Installation of 4 no. 1.2 x 1.2 UPVC white double glazed windows. Change of use from B1 (Business) & B8 (Storage & Distribution) to sheltered employment.

23/24 Orchard Business Park North End Road Yapton

Application Y/40/15/PL Proposal Installation of 4 no. 1.2 x 1.2 UPVC white double glazed windows. Change of use from B1 (Business) & B8 (Storage & Distribution) to sheltered employment.

PROPOSED INSTALLATION OF
4 NO 1.200 X 1.200 WHITE UPVC D/GLAZED
SINGLE OPENING WINDOWS SOUTH
SIDE

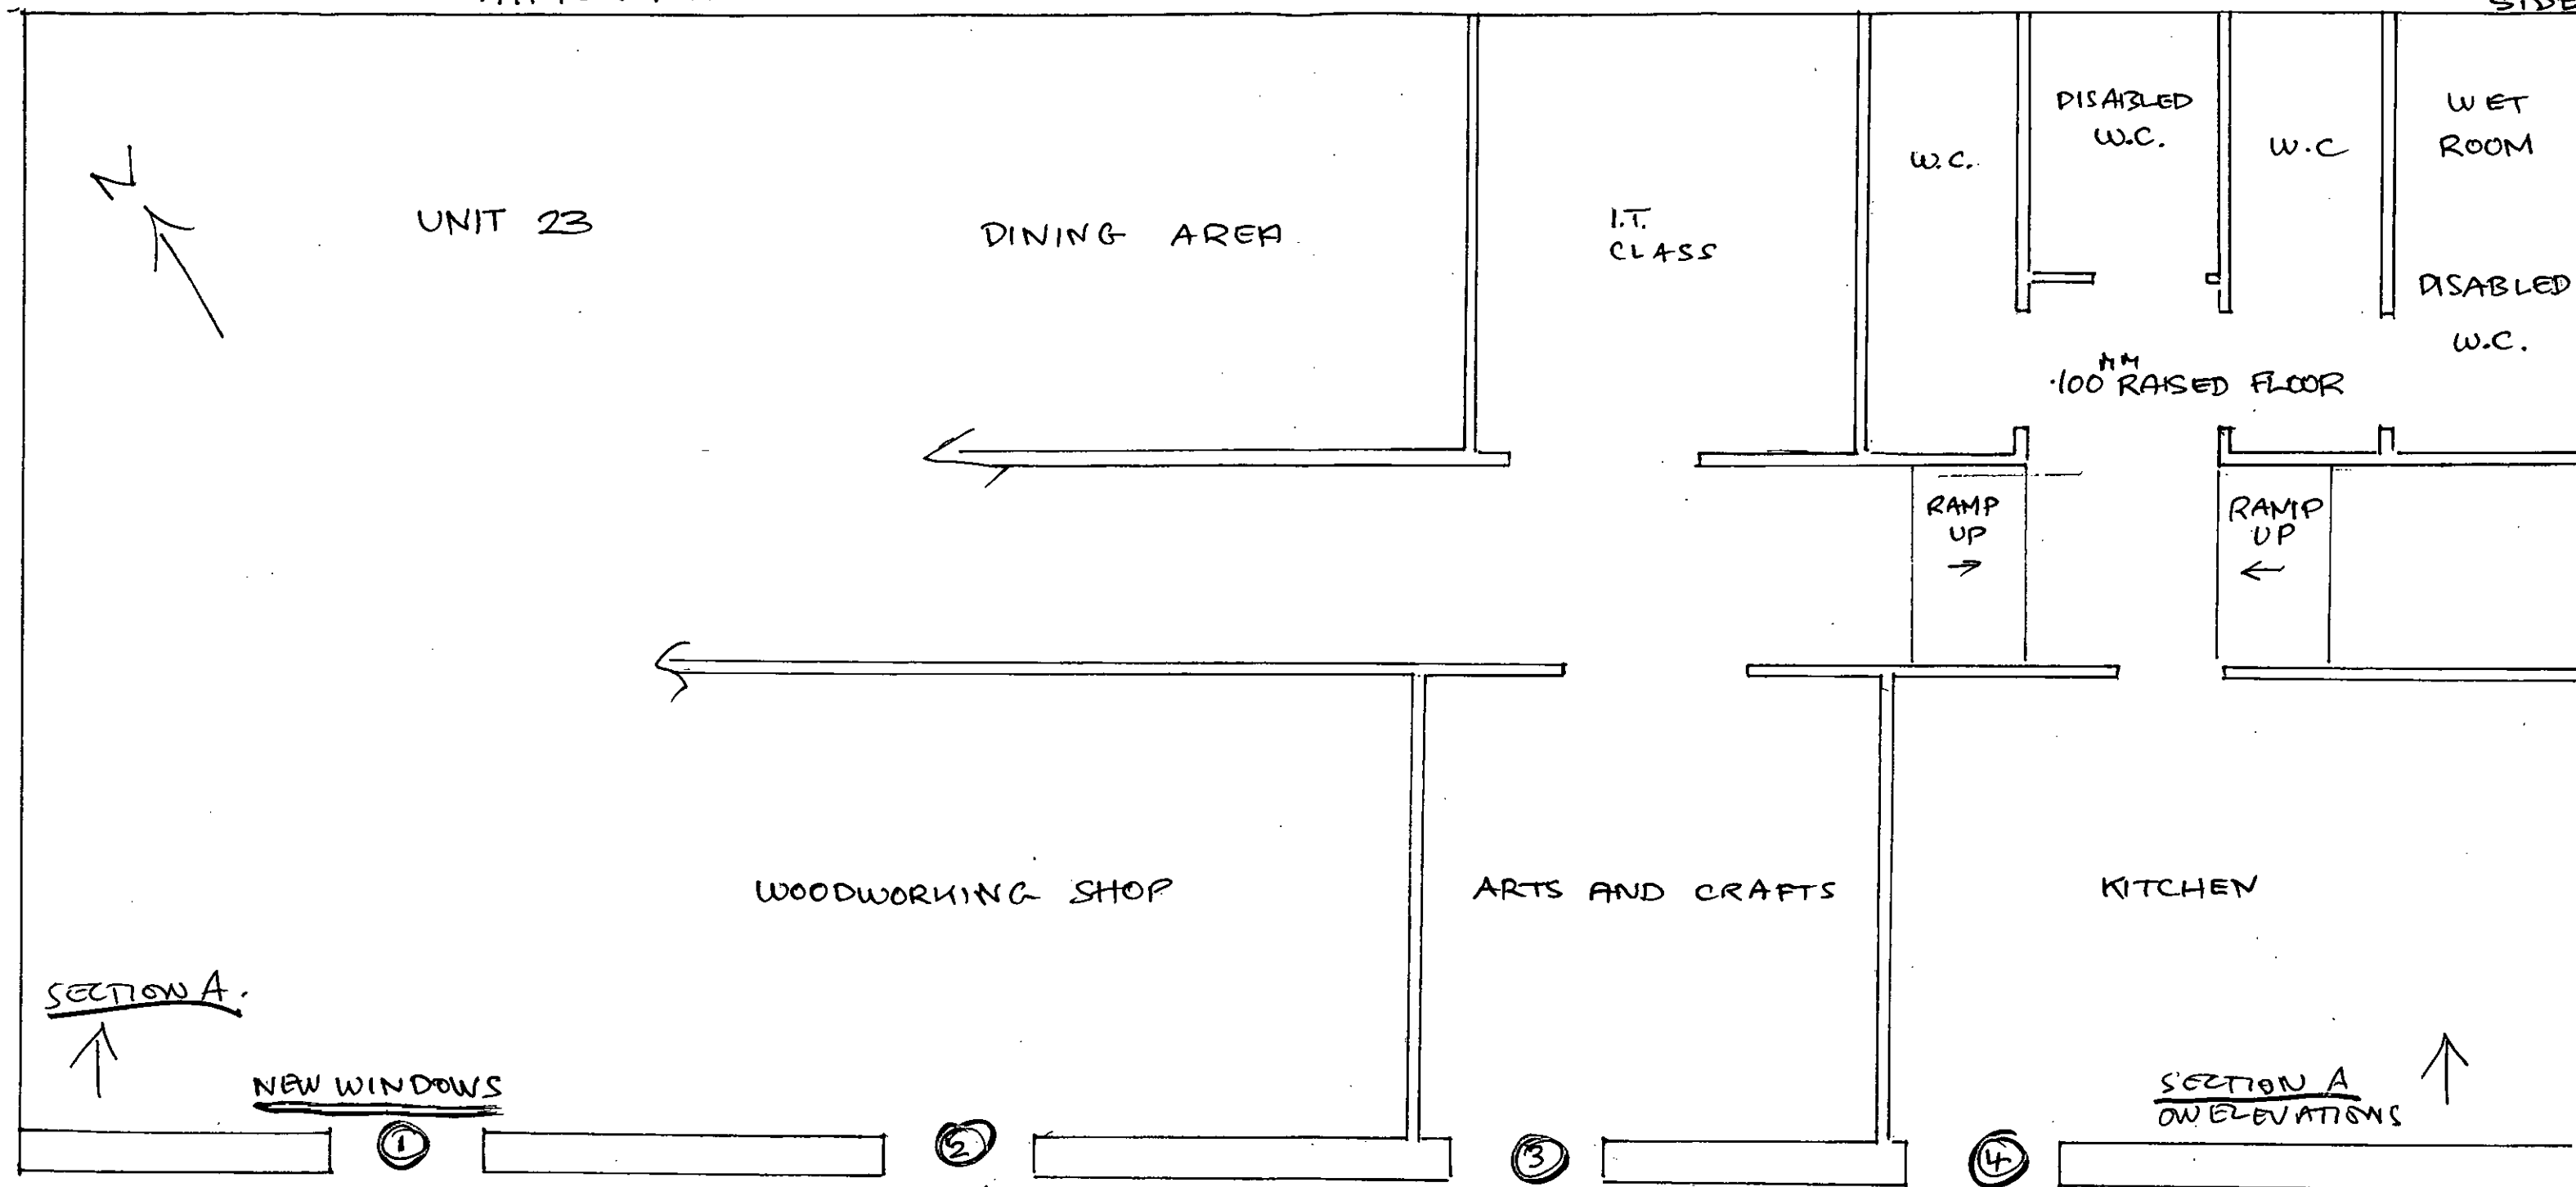
Given that this is another retrospective application on the site, condition 8 also states that none of the buildings shall be extended or altered in any way, nor shall any plant machinery or other structure be erected or constructed unless permission is granted by the local authority.

As the windows have already been installed this is clearly in breach of that condition, and given the close proximity to my neighbours I think this is unacceptable.
